Re: Application for improvement permit for K-Bar Hills lot 25

Health Department file No.10-5-25677

Based on the criteria set out in Title 15A, Subchapter 18A, of the North Carolina Administrative Code, Rules .1940 through .1948, the evaluation indicated that the site is **UNSUITABLE** for a ground absorption sewage system. Therefore, your request for an improvement permit is **DENIED**. A copy of the site evaluation is enclosed. The site is unsuitable based on the following:

SOIL/SITE EVALUATION
 for ON-SITE WASTEWATER SYSTEM

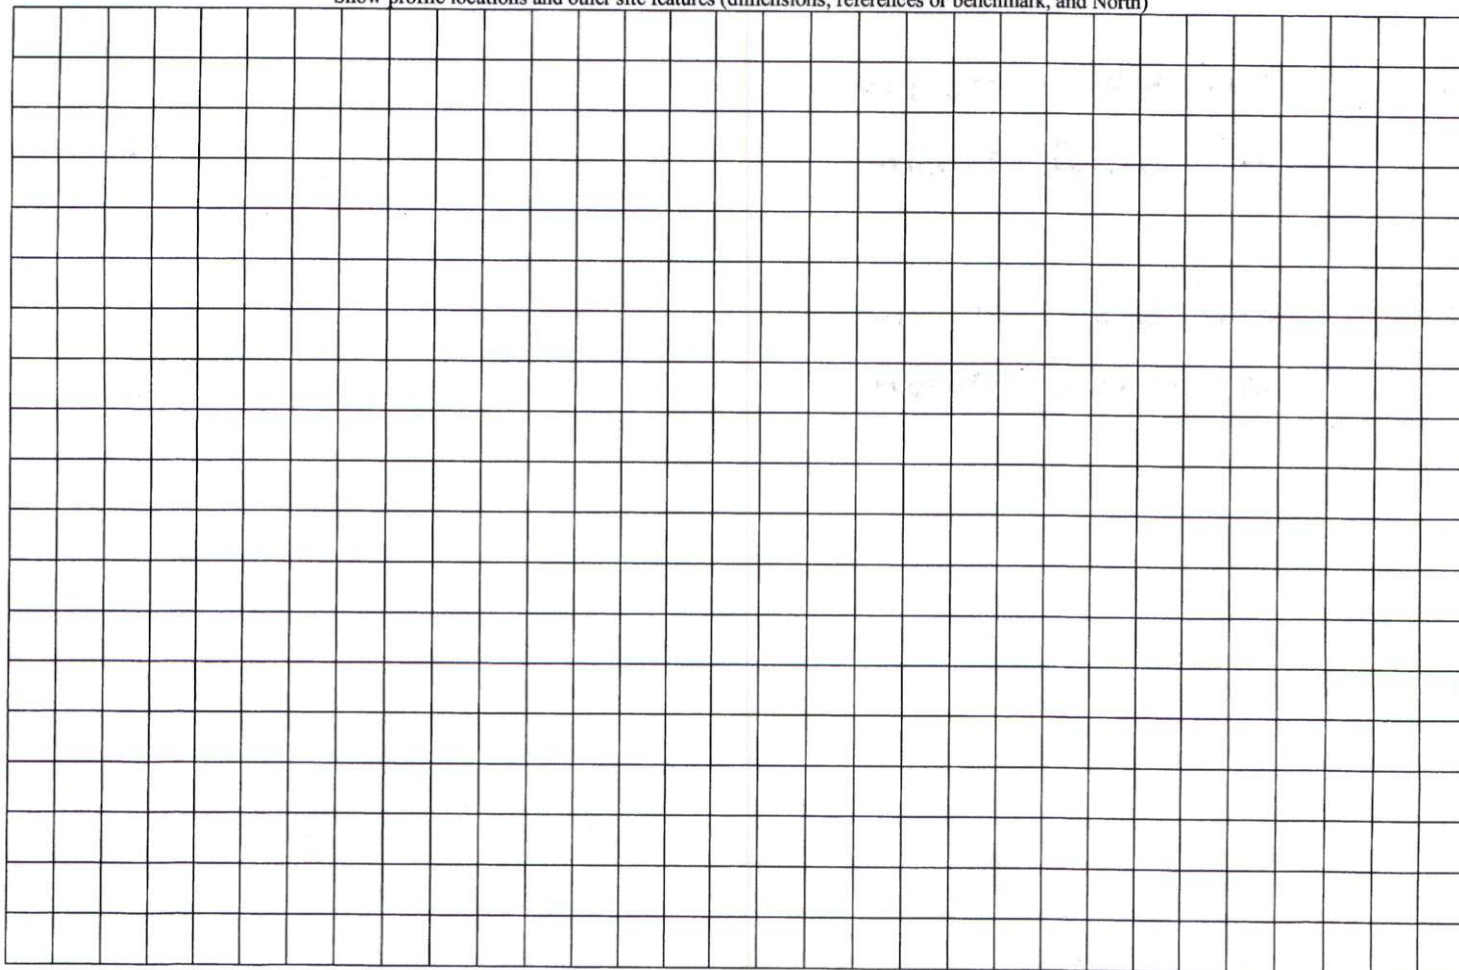
- ☐ Unsuitable soil topography and/or landscape position (Rule .1940)
 - ☒ Unsuitable soil characteristics (structure or clay mineralogy) (Rule .1941)
 - ☒ Unsuitable soil wetness condition (Rule .1942)
 - ☒ Unsuitable soil depth (Rule .1943)
 - ☐ Presence of restrictive horizon (Rule .1944)
 - ☐ Insufficient space for septic system and repair area (Rule .1945)
 - ☐ Unsuitable for meeting required setbacks (Rule .1950)
 - ☐ Other (Rule .1946) _____
- _____
- _____
